**Application for a non-material amendment following a grant of planning permission,  
Town and Country Planning Act 1990**

**Non material amendment to previous Reserved Matters approval 2025/92242  
(including consideration of appearance, scale and landscaping) for erection of 80  
dwellings, pursuant to Section 73 approval 2025/90105 pursuant to previous outline  
permission 2022/91735**

**Land off Hermitage Park, Lepton, Huddersfield, HD8 0JU**

**Application Number: 2026/91067**

CLIENT: MILLER HOMES
PROJECT: HERMITAGE PARK, LEPTON
DRAWING: SITE LAYOUT

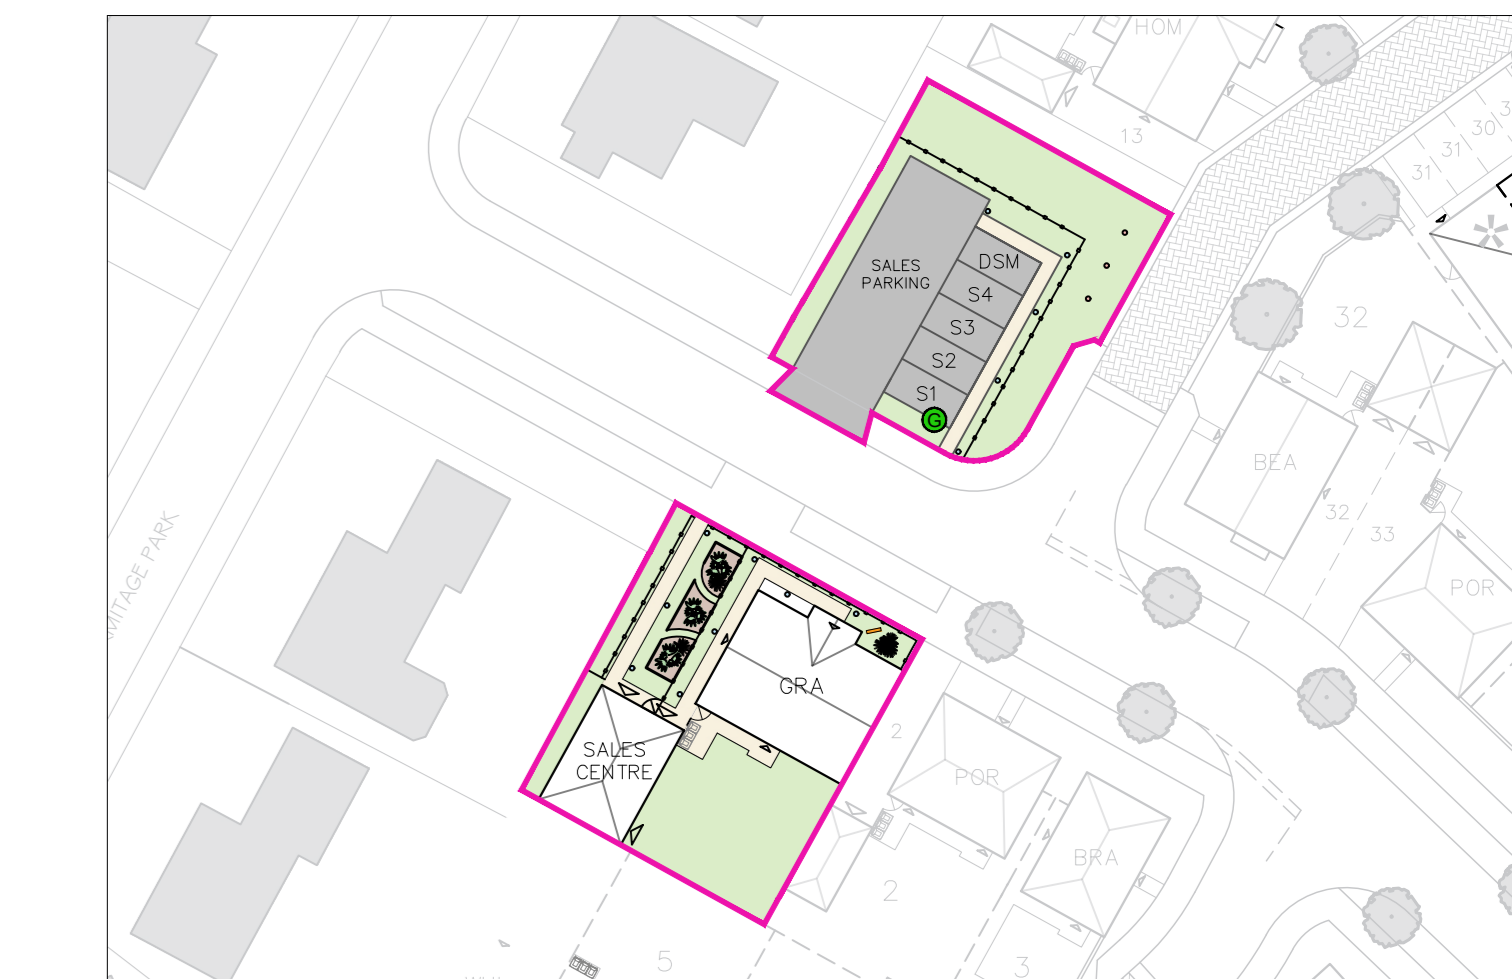
- Boundary between plots 9 and 10 amended, and boundary treatment set back from the road.
- Side door to house at plot 12 replaced with window.
- House at plot 15 handed, front parking spaces moved southeastwards.
- House at plot 16 moved southwards, garage moved northwards.
- Plot widths changed at plots 18 to 21.
- Houses at plots 19 and 20 (and detached garage at plot 20) moved eastwards.
- House at plot 21 changed from Greyford to Denford house type and moved northwards, garage (previously to be attached to garage of plot 22) and side driveway deleted, front hedge deleted.
- Garage at plot 22 now detached (no longer attached to garage at plot 21).
- Boundaries between plots 23, 24 and 33 to 36 amended.

- 1200mm vertical railings added to gardens of plots 6, 7, 8, 9 and 24 (and this newly-introduced railing added to drawing key).
- Houses at plots 23, 35 and 36 moved westwards.
- House at plot 33 moved northeastwards (away from the road).
- Garage at plot 34 moved northwards.
- Curtilage to plot 40 amended.

I confirm that the changes may be considered as non-material amendments to the approved drawings. They are considered acceptable, and are hereby approved.
